RE: FERNANDEZ TOWNHOMES (J19-D40)

PROJECT TITLE: FERNANDEZ TOWNHOMES ZONE ATLAS/DRNG. FILE #: J19-1540  
 DRB #: \_\_\_\_\_ EPC #: \_\_\_\_\_ WORK ORDER #: \_\_\_\_\_  
 LEGAL DESCRIPTION: LOT 39A BLOCK 11, SNOW HEIGHTS ADDN  
 CITY ADDRESS: PENNSYLVANIA ST NE

**SUPPLEMENTAL CALCULATIONS**  
**FOR**  
**FERNANDEZ TOWNHOMES**

SWALE SECTION A
1" = 2'

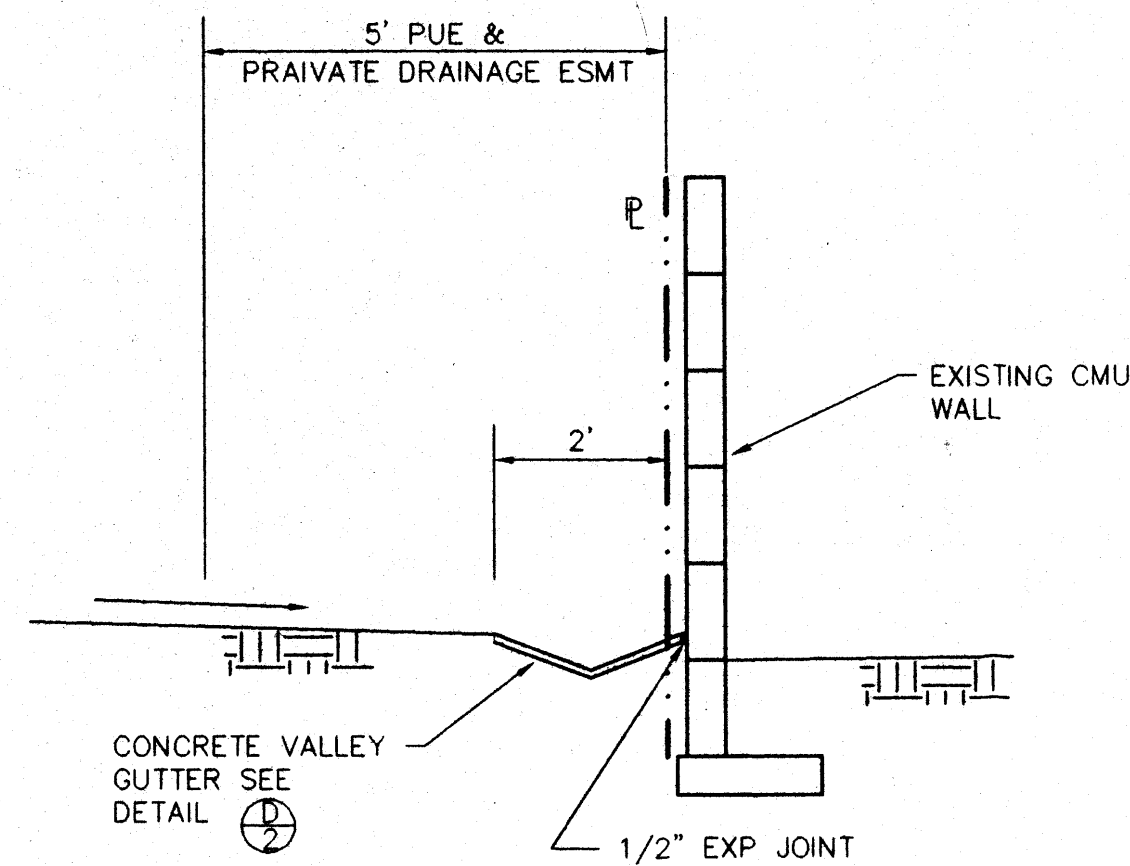
1. In response to your letter dated October 30, 1995: If buildings have not yet been designed, how did you come up with a footprint? I want to know how much water you are discharging to the rear yard. Show roof drain locations.
2. Cross lot drainage will require a concrete channel and proper easements and covenants.

2. Section "A" is provided on the Plan detailing a concrete swale within a private drainage easement. The easement will be granted by replat.
